Application No: K/2/22/HH
Site Address: 43 Golden Avenue East Preston BN16 1QX
Description of works: 2 storey front and rear extensions and alterations.

Thank you for your internet representation made on 3rd February 2022 which has been recorded as no objection with the comments as follows:

Dear Mr Unsted,
Arun D.C Planning application K/2/22/HH

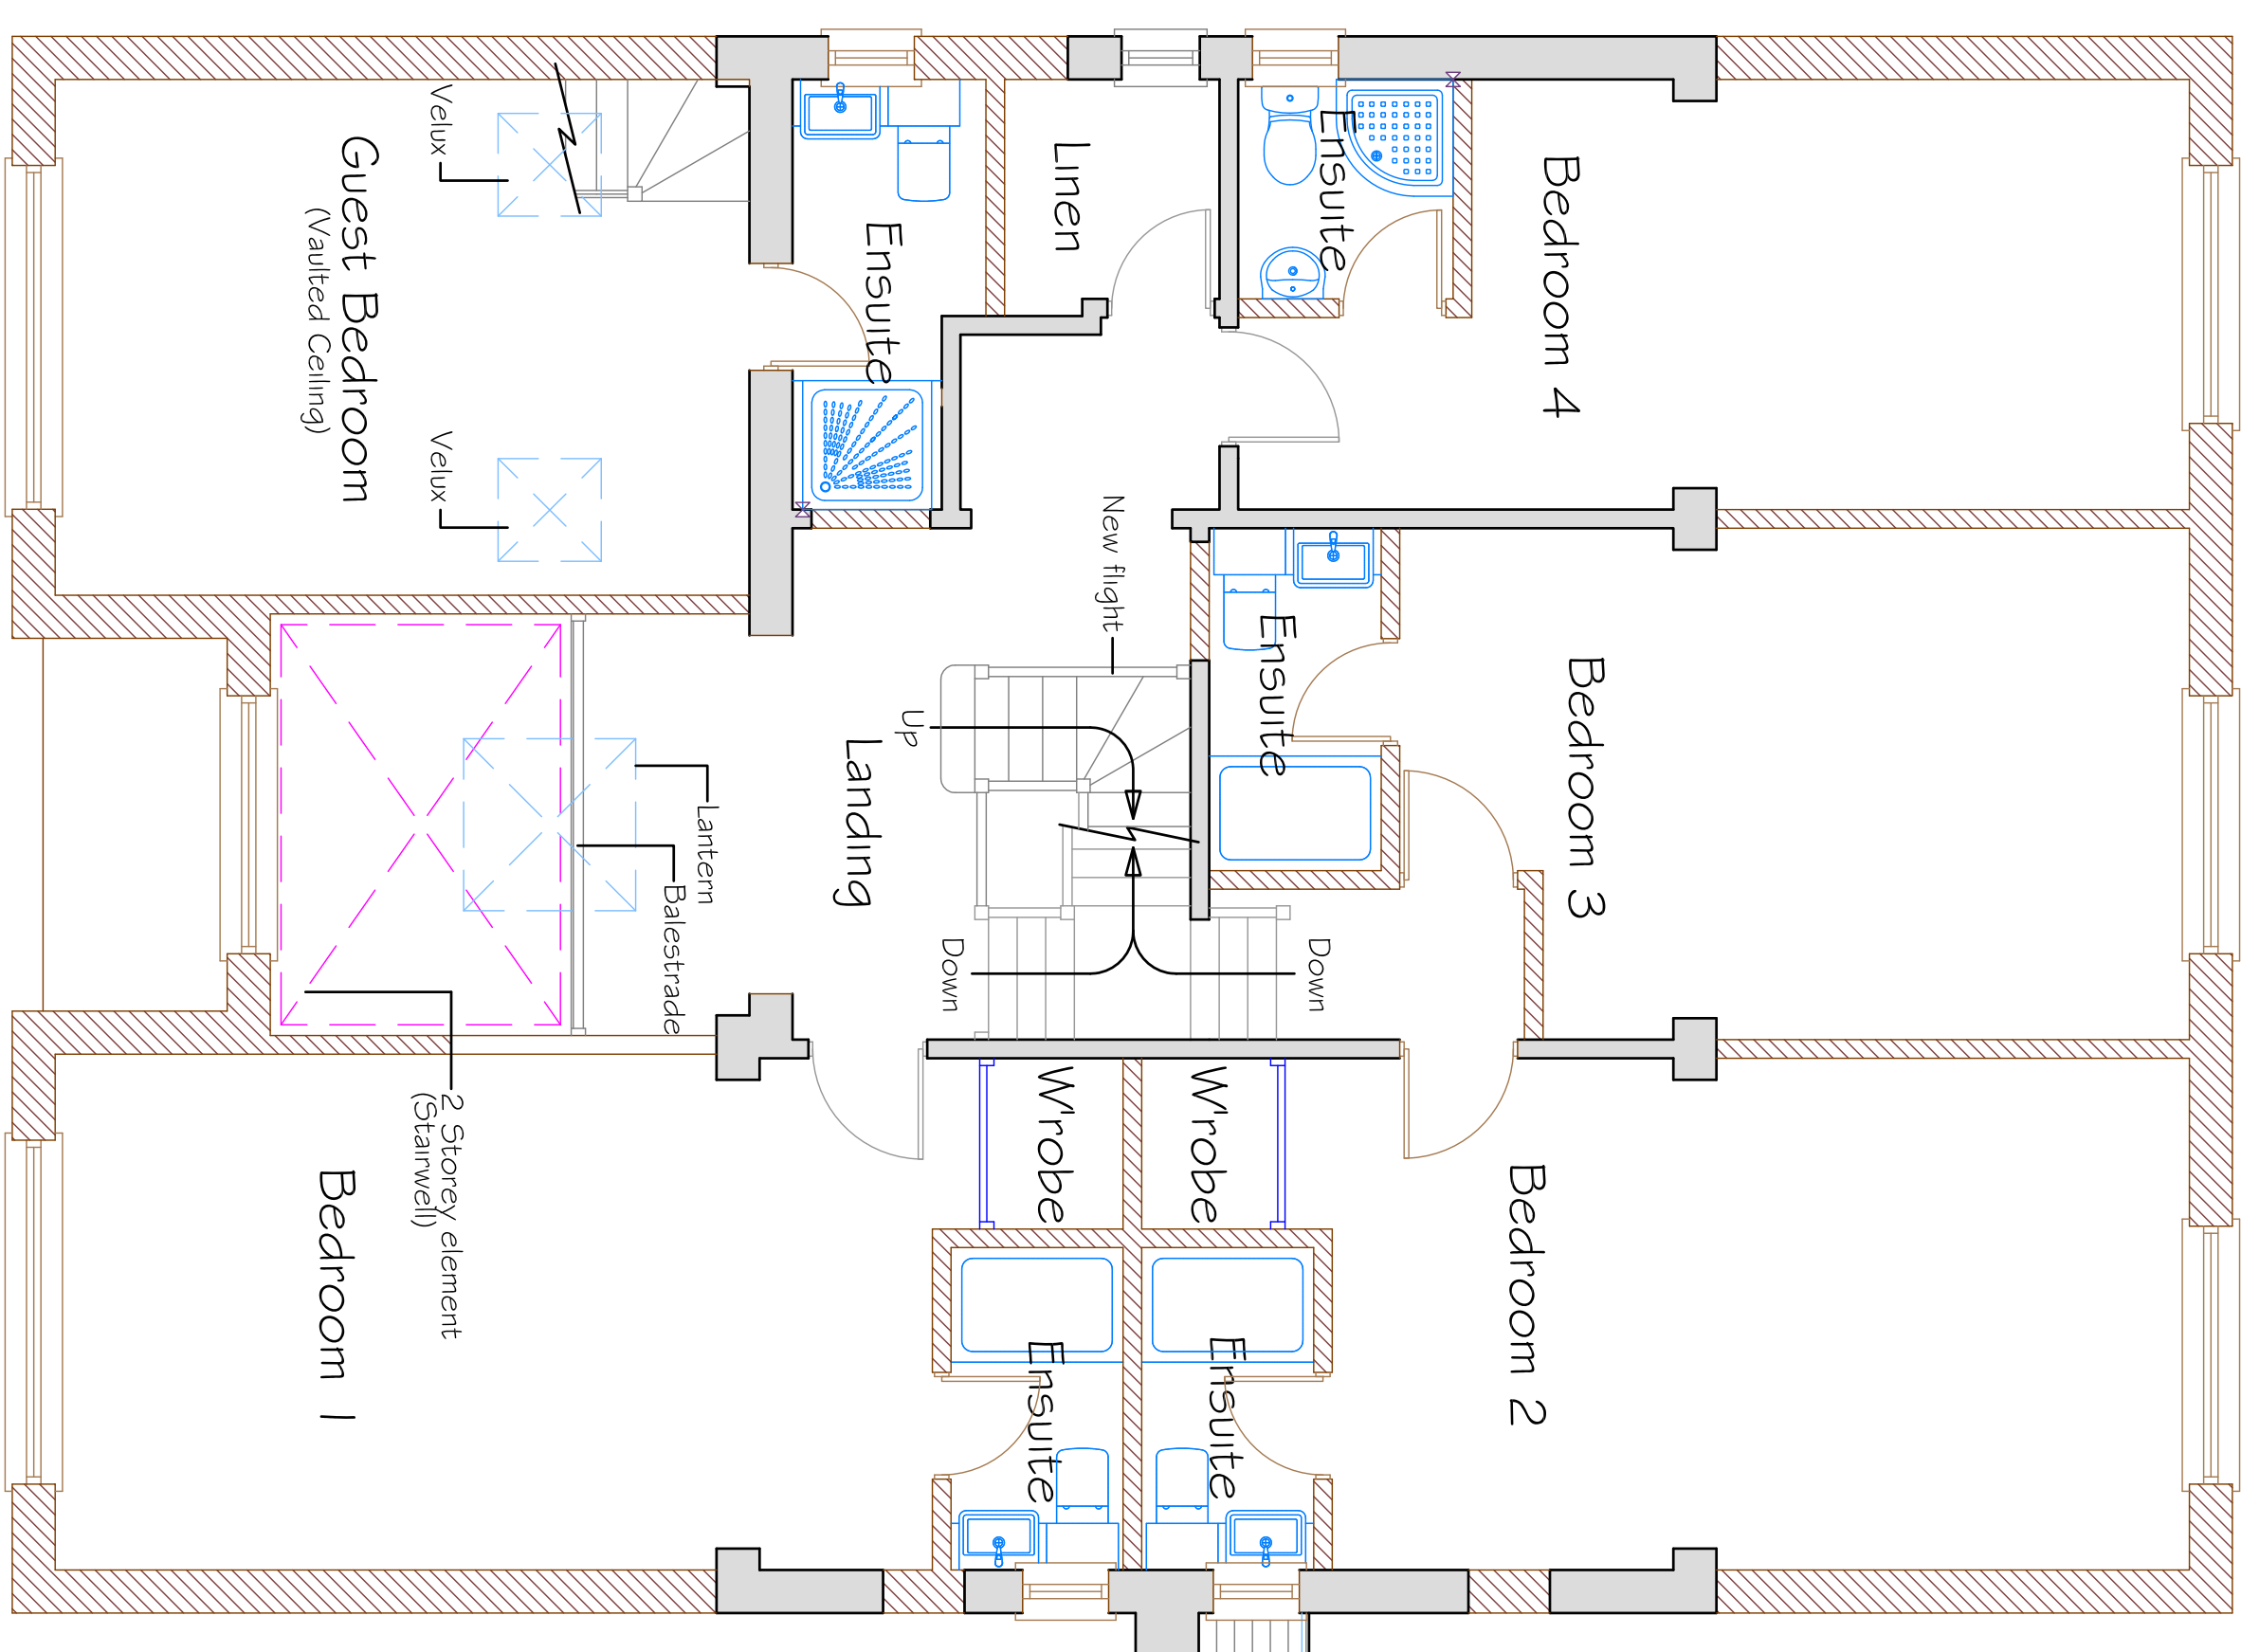
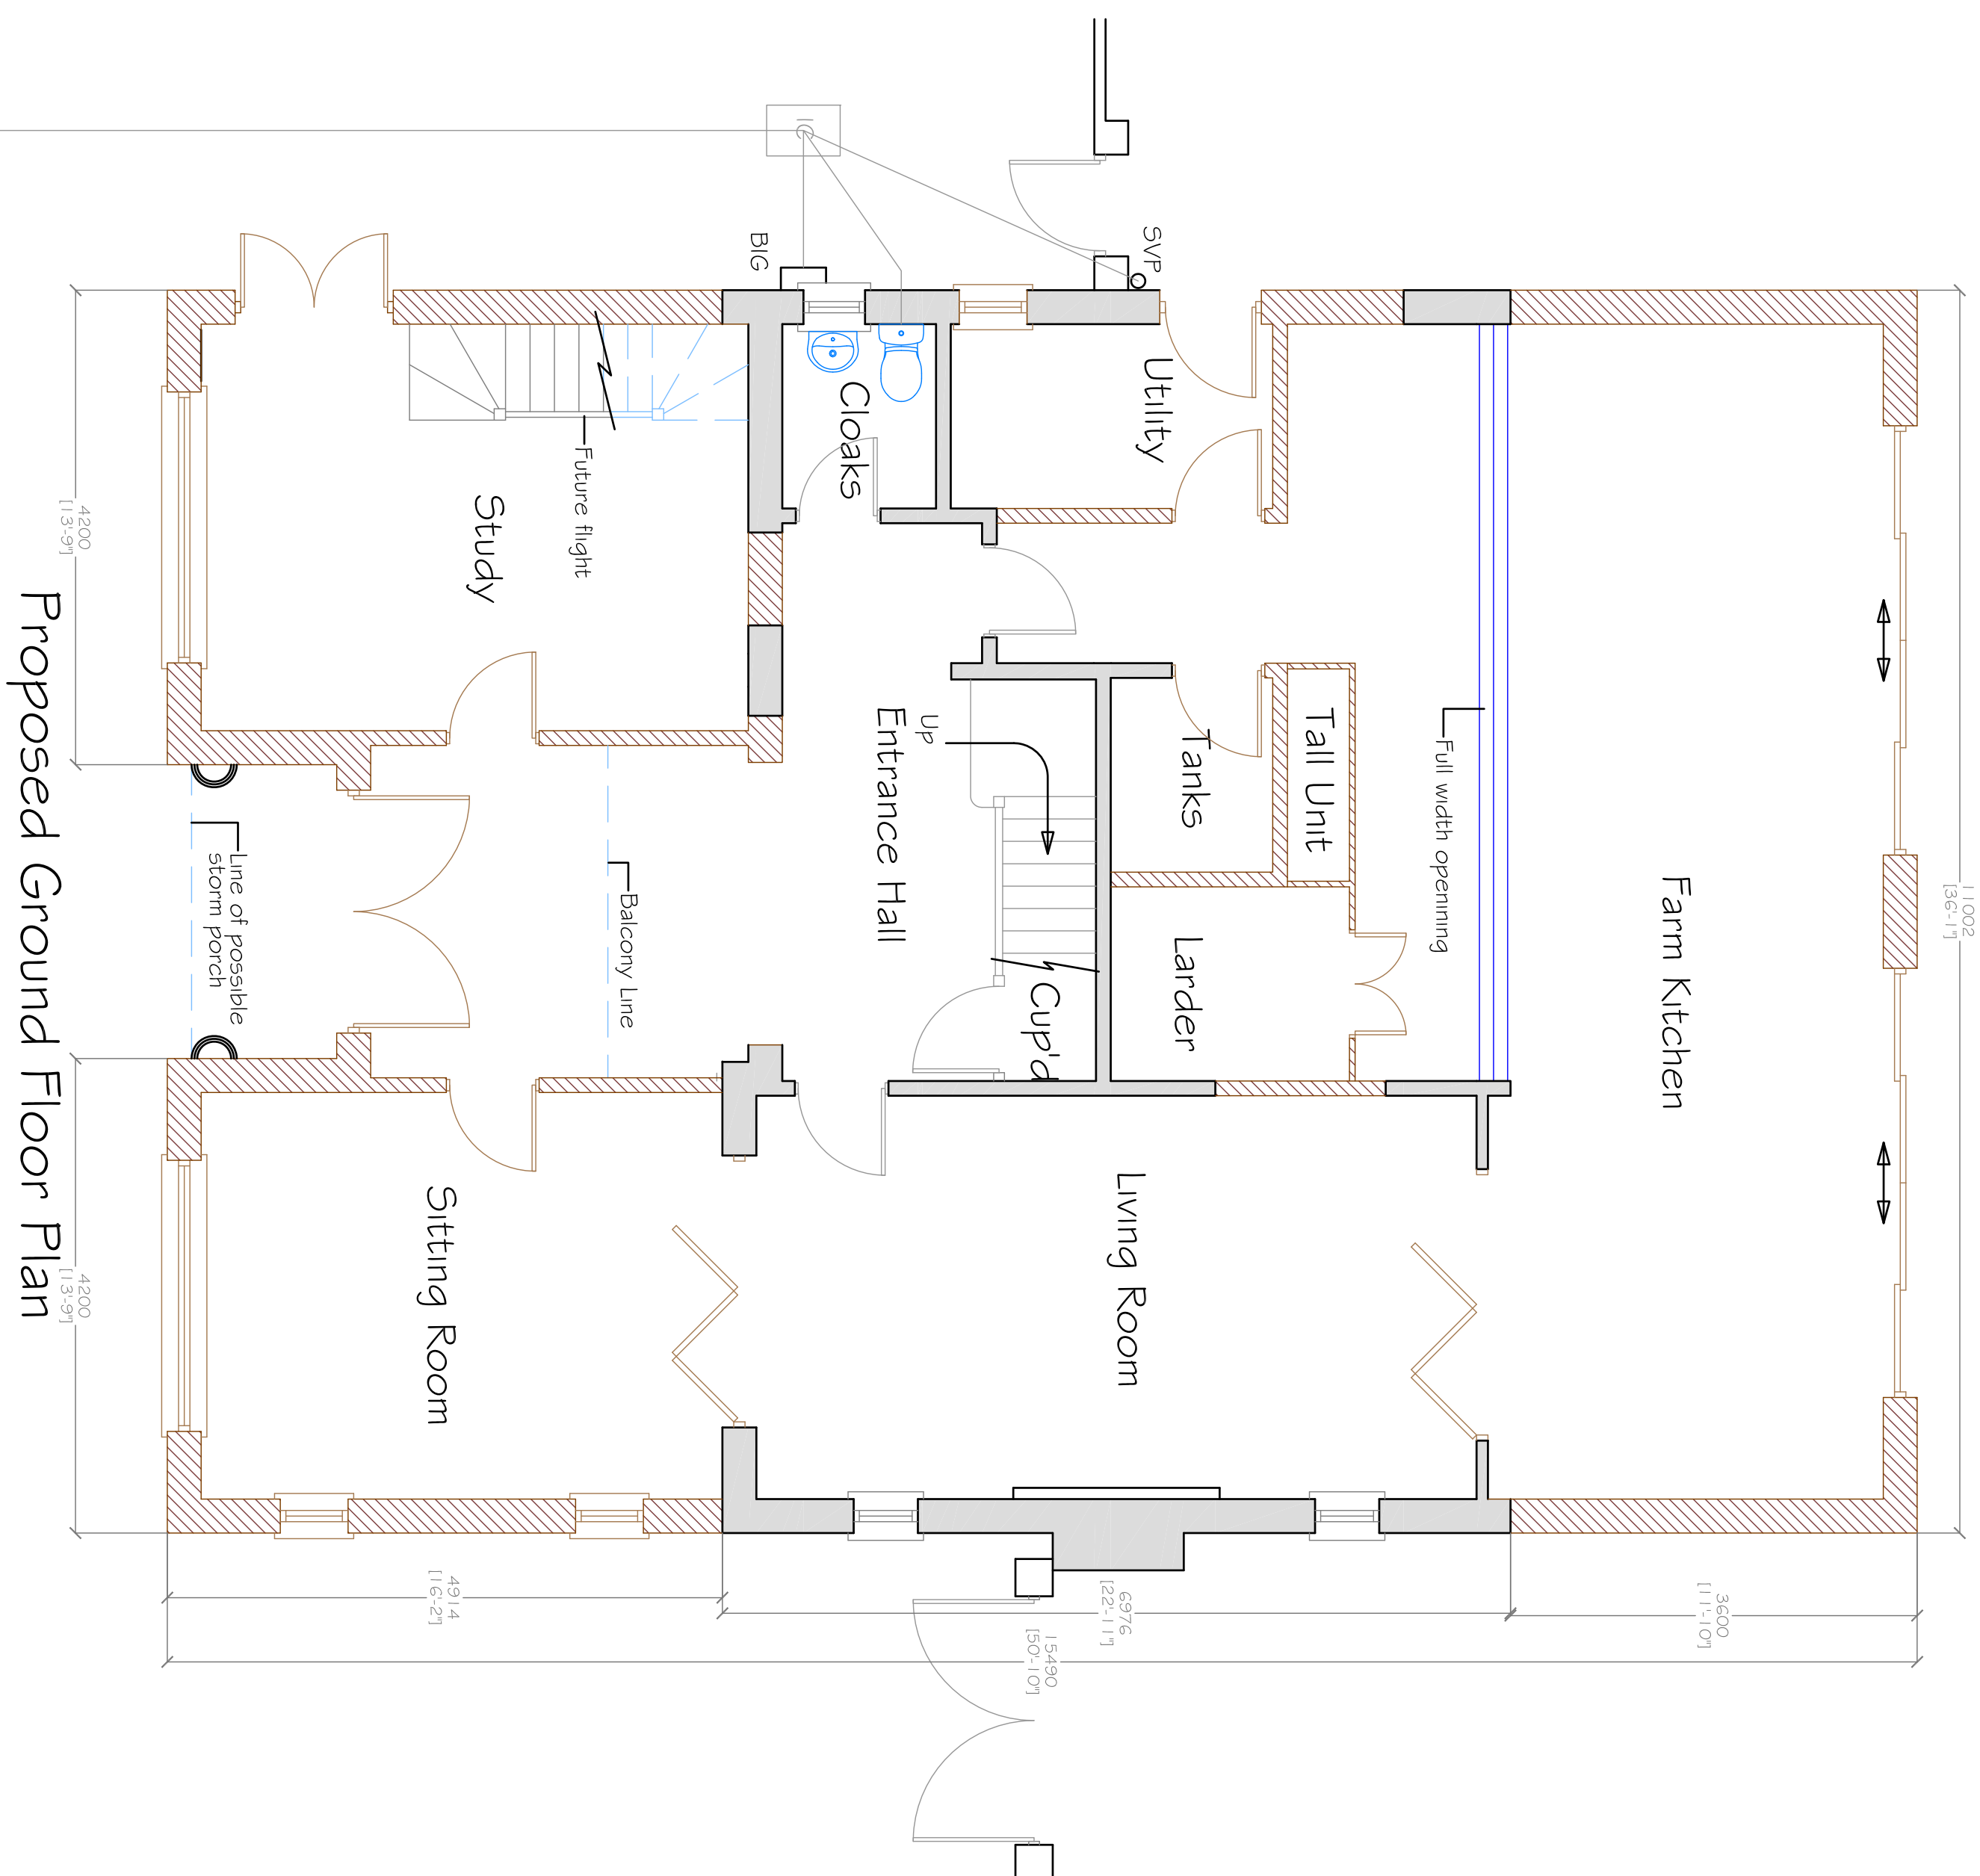
1. This is a major development of the site which seems to involve extending beyond the line of the existing garage. I don't know if a covenant is in place on that building as it is on my own house (No.44), which restricts any building closer to the boundaries on all sides. It does seem to be a small amount, but normally going beyond the building line is not permitted.
2. There appears to be no provision for parking suggested on the plan. The owner has several vehicles and I should have thought that adequate onsite parking was something he would be keen to accommodate. Our neighbours have also expressed concerns about the roadside parking.
